MEMORANDUM

DATE: November 15, 2022

SUBJECT: **On-Call Contract #17-067H-1; PO # 8115428**
Traffic Impact Study Reviews
Task Order #6: Lorson Ranch Commercial TIS – Second Review (P2211)

This memorandum provides a list of comments on the October 2022 Lorson Ranch Commercial Traffic Impact Study (TIS) prepared by Matrix Design Group for The Landhuis Company. Our comments are based on requirements provided in the County’s Engineering Criteria Manual (ECM), Appendix B.

Figure 11. Lorson Ranch Commercial Project Trips (AM Peak Hour)

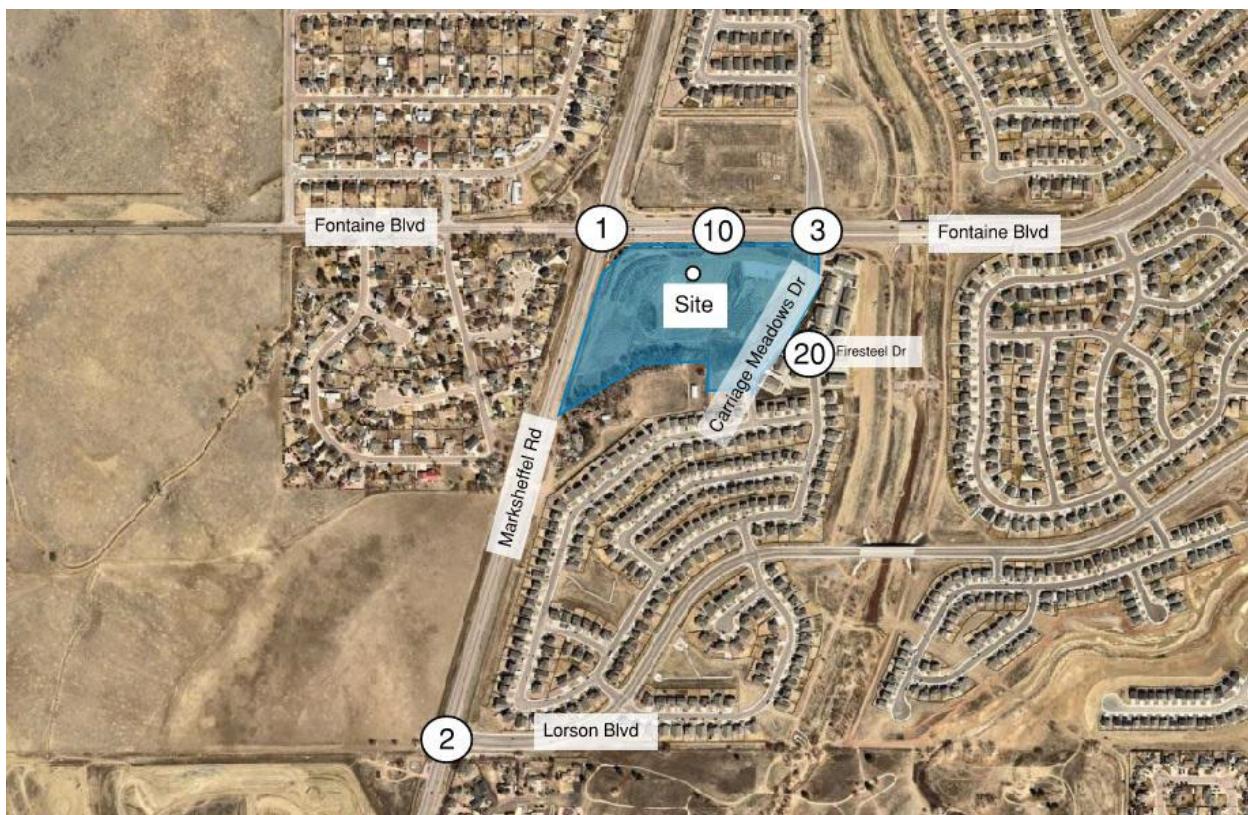
2. We recommend disapproval of the deviation request for a new access along Fontaine Boulevard from a traffic perspective.
 - a. The access serves less than 160 vehicle trips (combined entering and exiting) based on Figure 11 and Figure 12 in the TIS.
 - b. Based on the 2040 Total Traffic levels of service shown in Table 10 and Table 11, the Fontaine Boulevard / Carriage Meadows Drive intersection (#3) and the Access 2 / Carriage Meadows Drive intersection (#20) should be able to accommodate these trips.
 - c. Fontaine Boulevard is forecasted to operate over its theoretical capacity adjacent to the new access per the text on page 38 of the TIS.

Based on the comments above, we feel that the subject TIA should be updated and resubmitted. The revised study should update the operational analyses and either remove the Fontaine Boulevard site access or provide additional justification for retaining it.
